Subject: RE: 3/2011/1069 - Stonecroft, Longridge

Please find below my comments in relation to landscape aspects of the proposed wind turbine at Stonecroft, Jeffrey Hill, Longridge:

Views from proposed turbine location, looking in all directions, demonstrating the landforms and landscape features in the immediate vicinity of the site. It is clear from these photographs that the site is afforded some screening by the existing rolling landscape and trees.

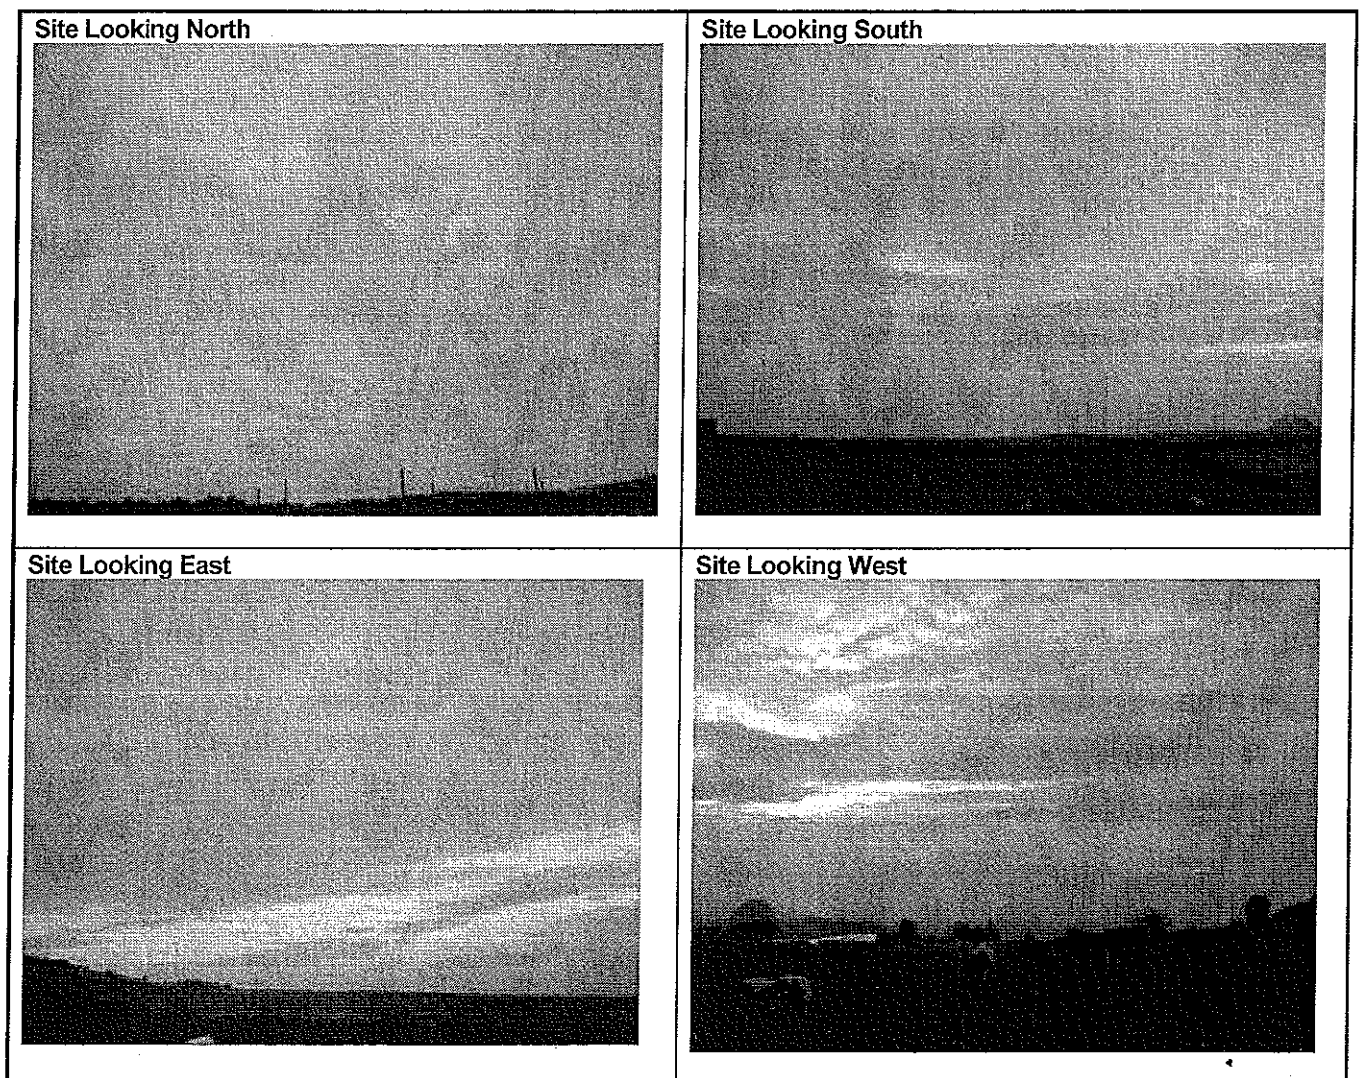
- The photographic survey pictures have no grid references for the viewpoints. In addition the photographs have a narrow field of view and show far too much sky.

Montage of turbine looking north

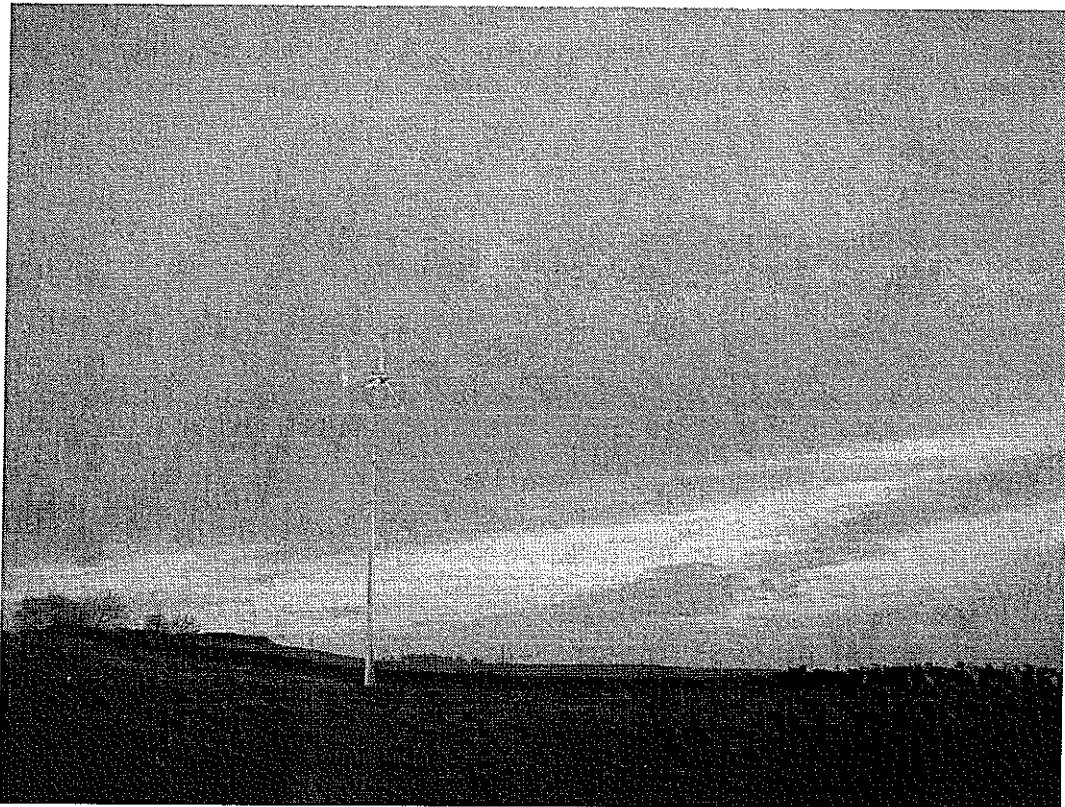
- The single photomontage provided is of questionable value as it has clearly not been produced in accordance with current good practice such as that provided in **Visual Representation of Windfarms, Good Practice Guidance, 29 March 2006** (Scottish Natural Heritage). In fact there is not even a grid reference provided for the location of the viewpoint used to produce the photomontage nor are there any details of the methodology used to produce it. The photomontage has a relatively small field of view which means there is little opportunity to appreciate how the wind turbine would appear in the wider landscape. Because of these issues I am afraid that I cannot place any reliance on the submitted photomontage to provide an adequate representation of how the turbine would appear in the landscape. In addition I consider that additional photomontages are required to provide a more comprehensive coverage of the proposed wind turbine's likely impacts on the wider landscape. I would be happy to assist with the selection of additional viewpoints.
